Our Ref: BE/81/18/PL
Your Ref:

Development Change of use of the property from dwellinghouse to mixed use dwellinghouse & attached building for the operation of a hairdressing business (A1) & retention of attached building.

Location 324 Chichester Road Bersted

Drawing 3 - Proposed Site Plan
Scale 1:200 @ A3

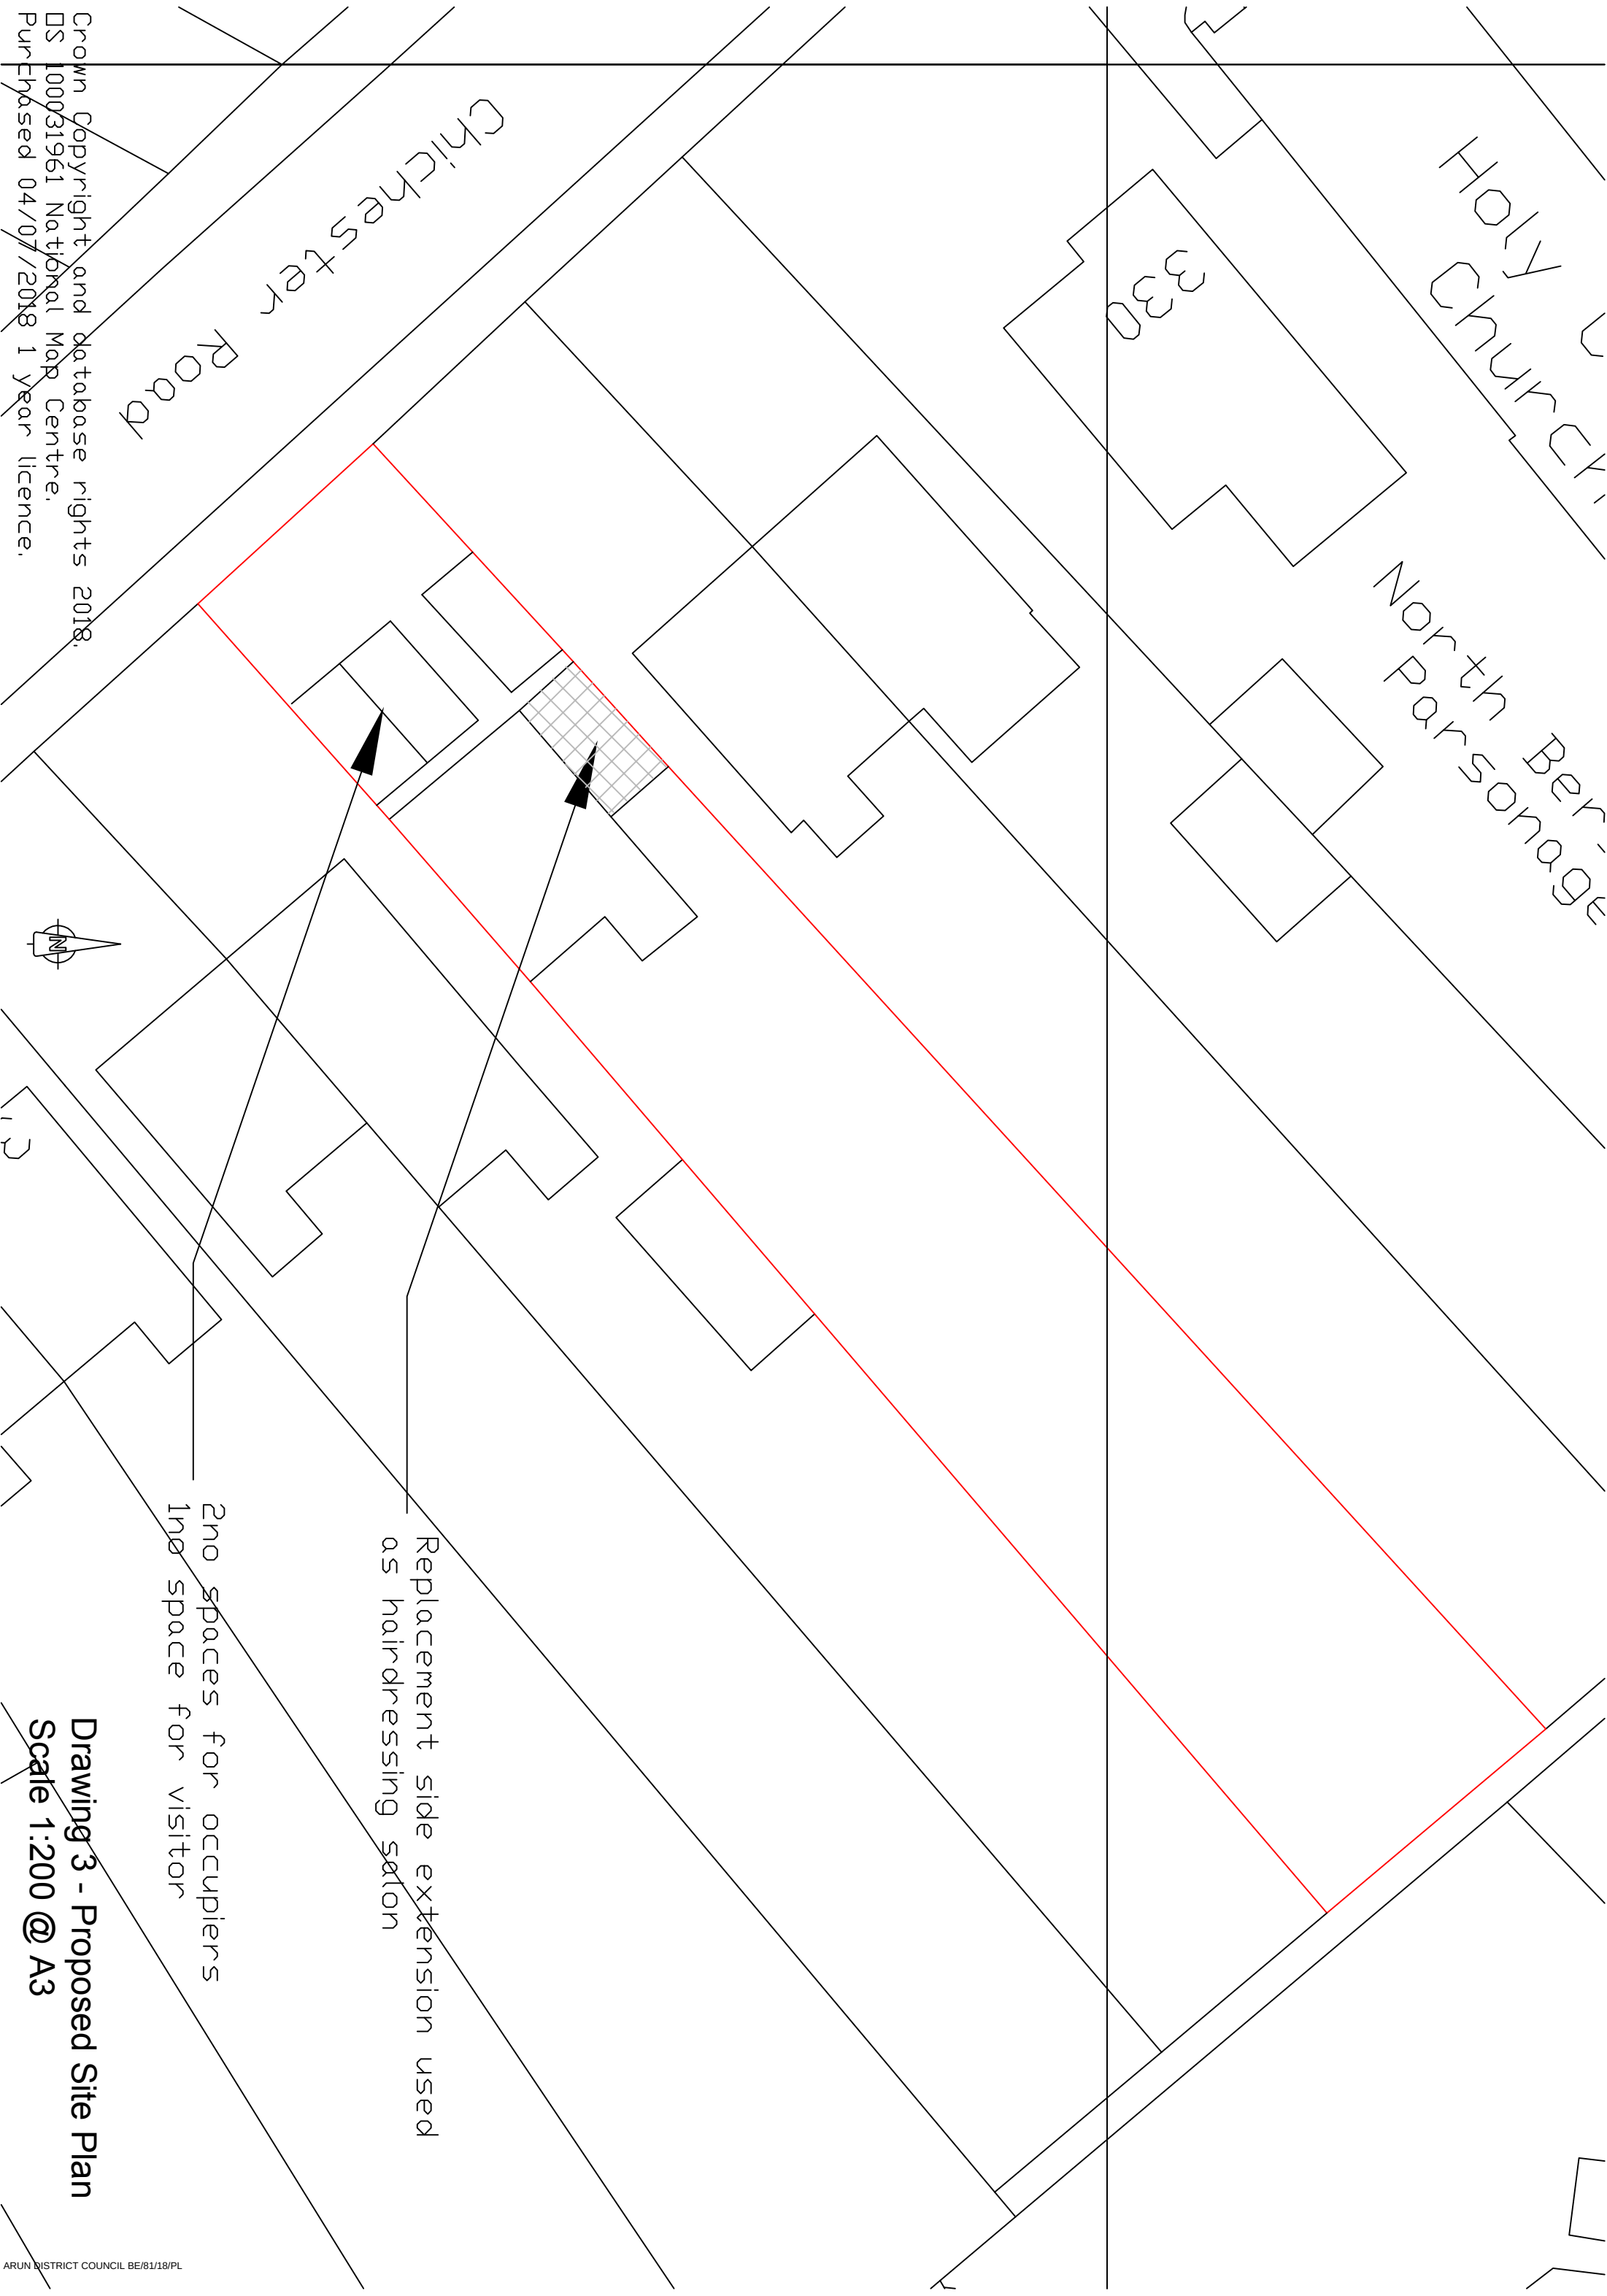
Block Plan

Please submit 1 electronic or 3 paper copies of a block/site plan at an amended scale of 1:500 or 1:200 showing the measurements from the extension to the boundaries.
